PLANNING APPLICATION R/31/26/HH: 15 EVELYN AVENUE BN16 2EJ

We are responding to Nat Design's 19 March letter to you in response to Rustington Parish Council's objection to the above application, which we think should not go without comment.

Proposed Roof Plan
1:200 @ A3

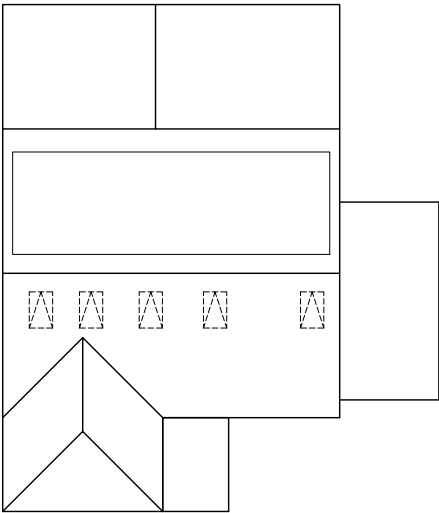
“The suggestion that the proposal would fundamentally disrupt the street scene does not properly account for the lawful fallback position, which would result in a very similar visual outcome.” This simply highlights the fact that the character of the street was not properly considered in relation to the permitted development. But the five rooflights make this even worse.

Rev	Notes	Date
 M: 07599199759 E: info@nat-design.co.uk www.nat-design.co.uk		
Project:		
15 Evelyn Avenue Rustington BN16 2EJ		
Drawing:		
Proposed Elevations		
Drawn by NSE		Scale as shown
Date Feb 2026		Revision
Drawing		
2027 - DPA - 06

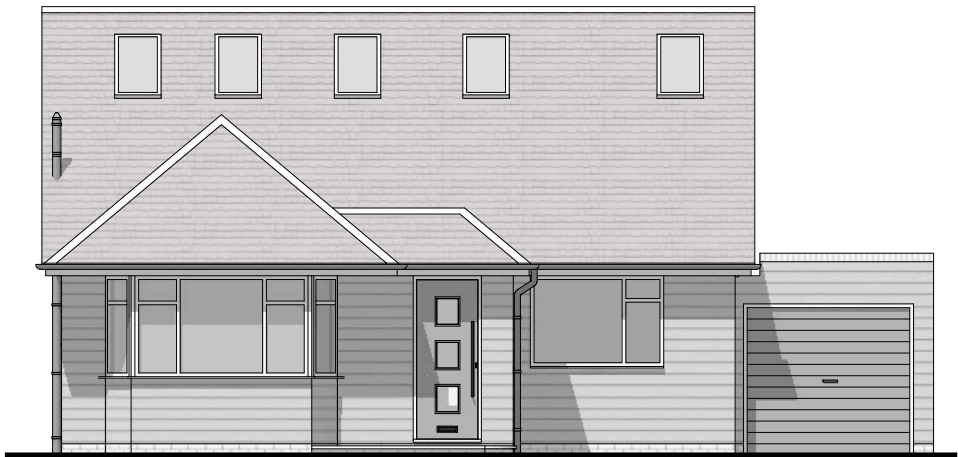
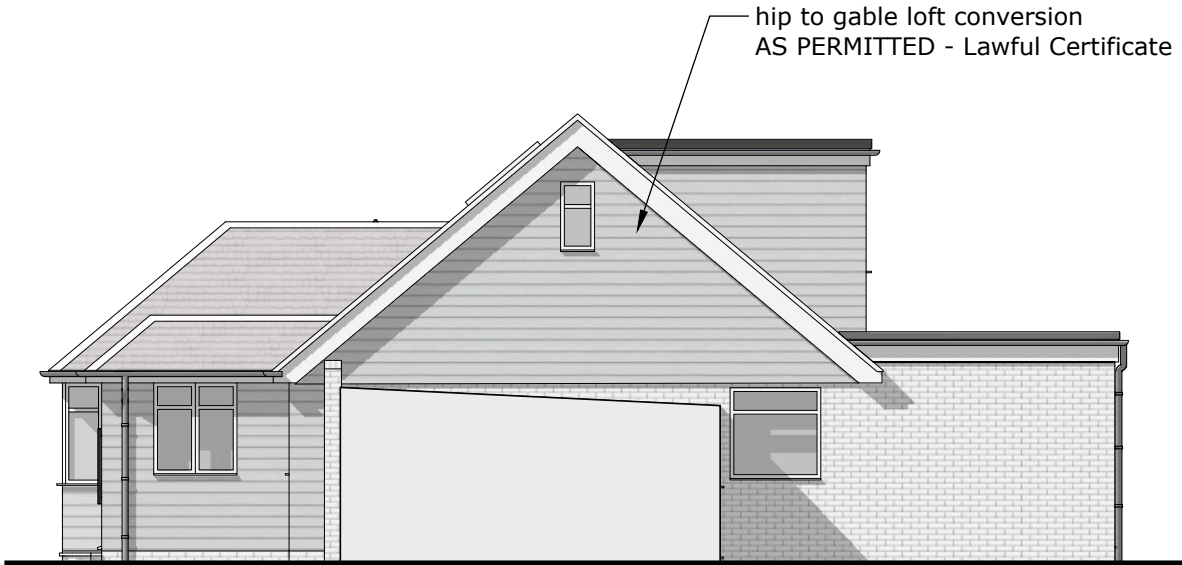
"A modest enlargement to the approved dormer" is not a justifiable characterisation. It is virtually the full width of the bungalow, which is almost 9 metres, rather than protruding at the mid-point of the pitched roof and it is double the width of the permitted development. This seems contrary to guidance in the Arun District Design Guidance that dormers should be "a minor incident in the roof plane".

The LDC dormer is only about half the width of the proposed dormer, being subject to permitted development limits. If this is substantial, the one to replace it would be massive.

See above comments on the increase in size of the dormer. Also the LDC dormer has only one, central window, overlooking much less than the two windows towards the ends of the dormer.

As explained above, this is more than “a minor variation”. The new dormer is virtually the full width of the bungalow (nearly nine metres), about twice the width of the permitted development. This is not “a simple and unobtrusive form which does not overpower the existing or neighbouring properties” in accordance with the Arun District Design Guide.

Brick is more than a common material in the immediate vicinity and even the wider area (Rustington Village Design Statement Character Area 6). It is overwhelmingly in evidence and is specifically mentioned in the listing of the Architectural Features of the area. Cladding is only used in Evelyn Avenue for five gable infills and extensive cladding as proposed is hardly to be seen in the local area.

Furthermore, No 15 sits in the middle of a row of eleven identically built bungalows that are architecturally uniform and do not have cladding. Indeed, the LDC was amended at Arun DC’s instigation to exclude the introduction of cladding, though this is not shown on the plan with this application.

It should be self-evident that this use of cladding would be completely out of character with the properties in Evelyn Avenue. And the cladding at the sides of the proposed development would be visible from the street as well as the cladding on the front. Also, the cladding of the full width rear dormer would make it even more intrusive.
